From: Contact Centre (CRM) <contact@ribblevalley.gov.uk>
Sent: 23 July 2023 18:58
To: Planning
Subject: Planning Application Comments - 3/2023/0439 FS-Case-533744708

Planning Application Reference No.: 3/2023/0439

PROPOSED FIRST FLOOR PLAN
Scale 1:50

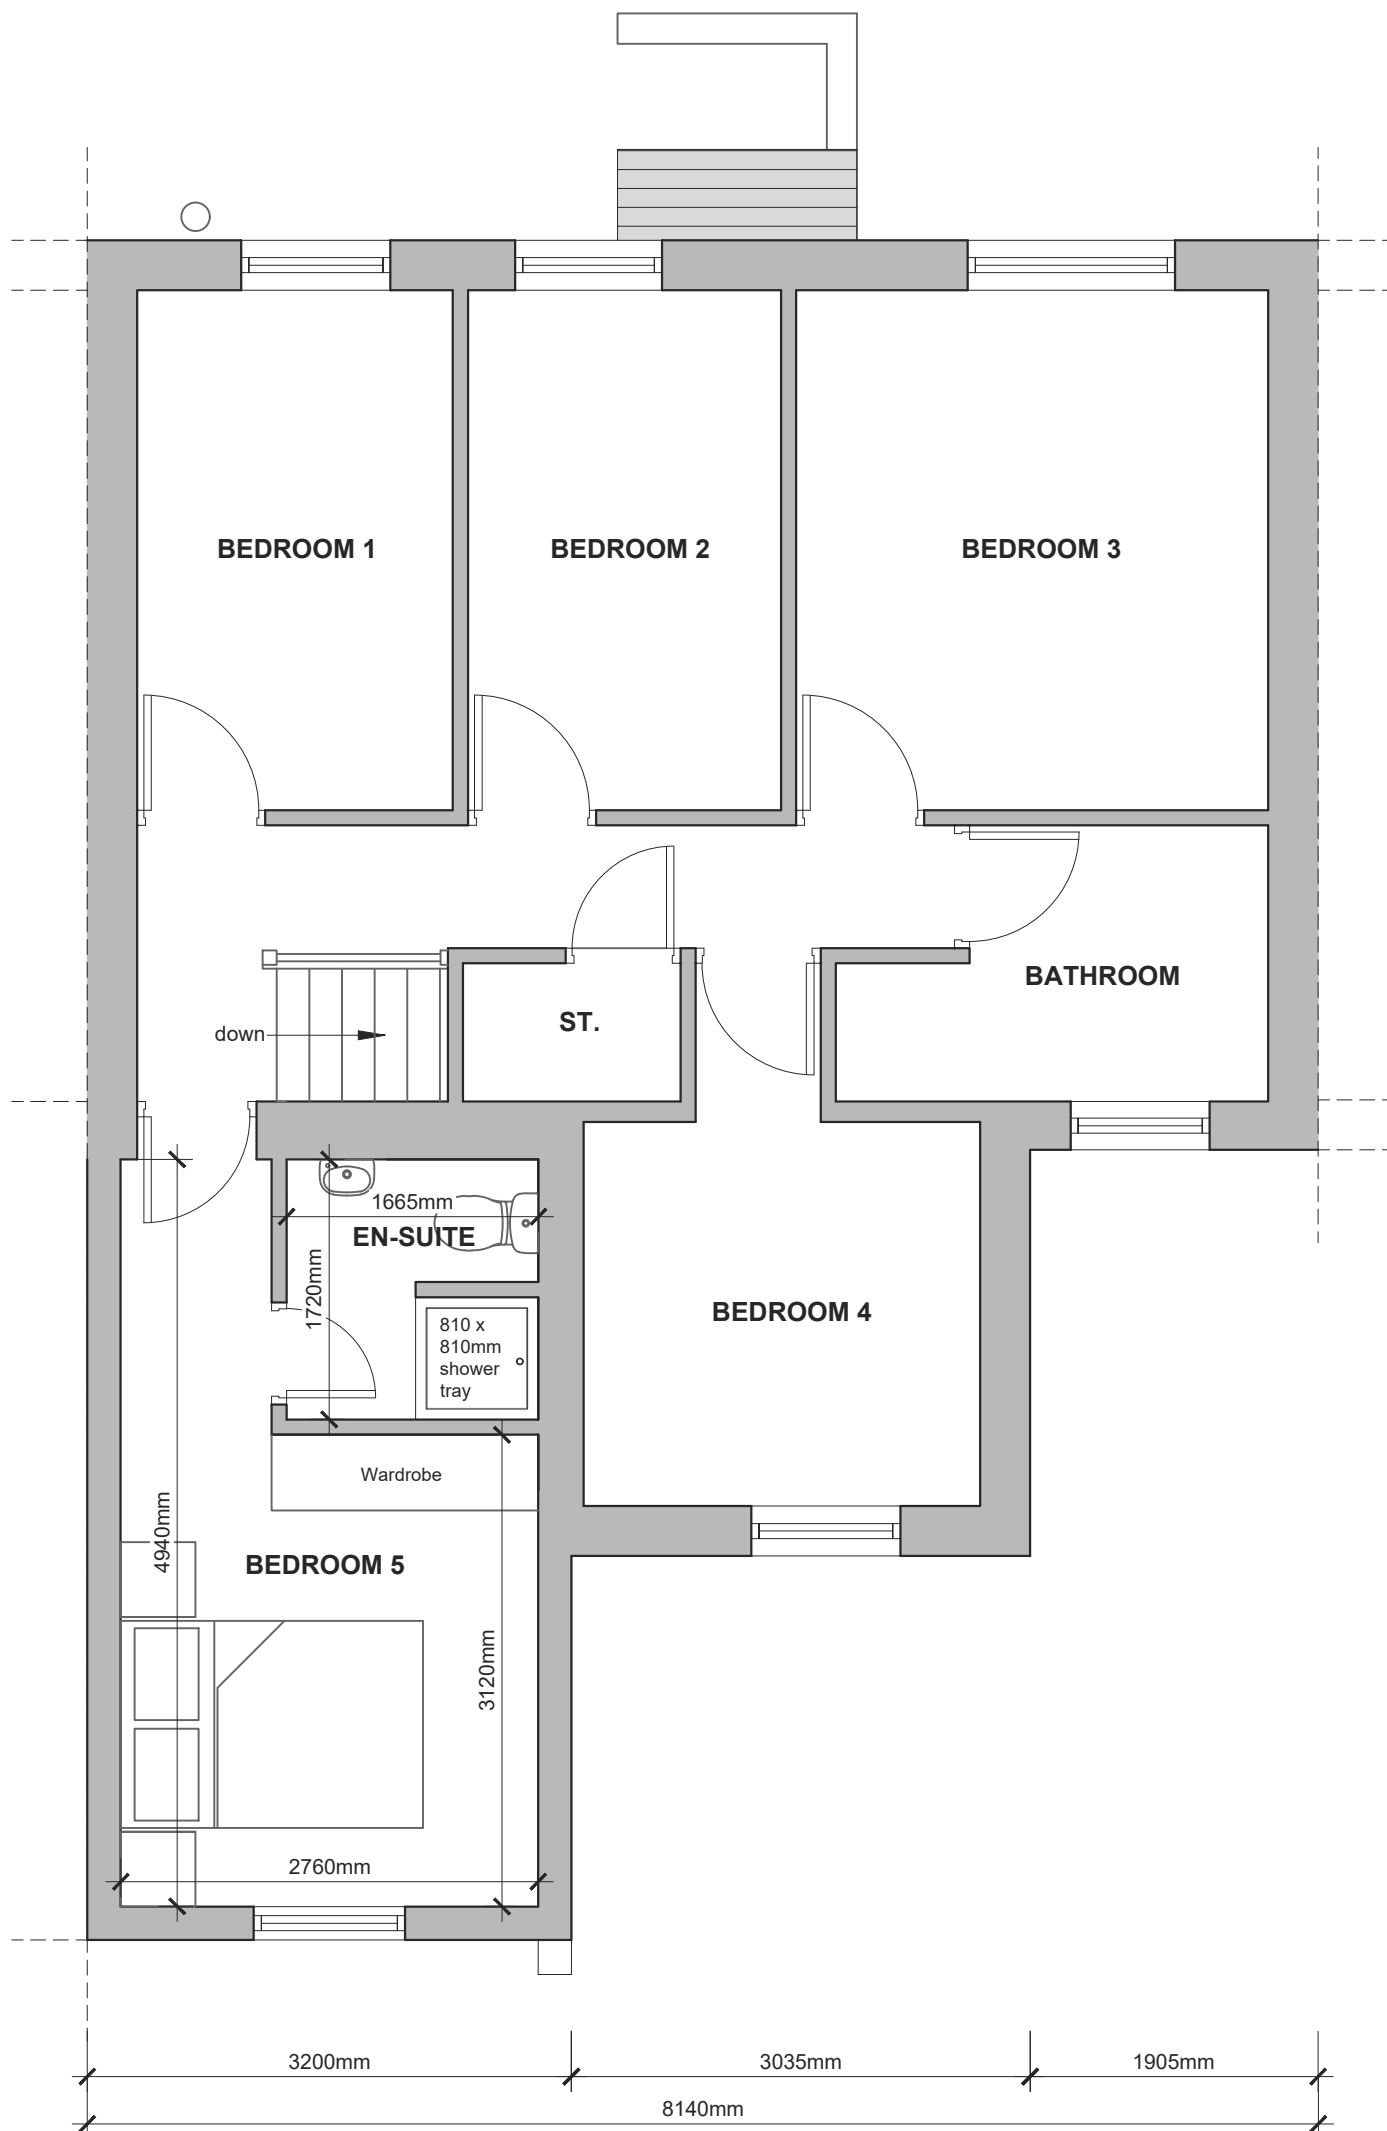
6. The proposal will compromise the amenity [REDACTED] As mentioned earlier, the proposed first-floor extension will effectively protrude from the original rear wall by over 4.5 metres. The architects call it an infill which does not imply a major extension but it should be noted that it is proposed to be built over an existing ground floor structure which used to be a garage originally. It is effectively extending by stealth and as such would compromise [REDACTED]
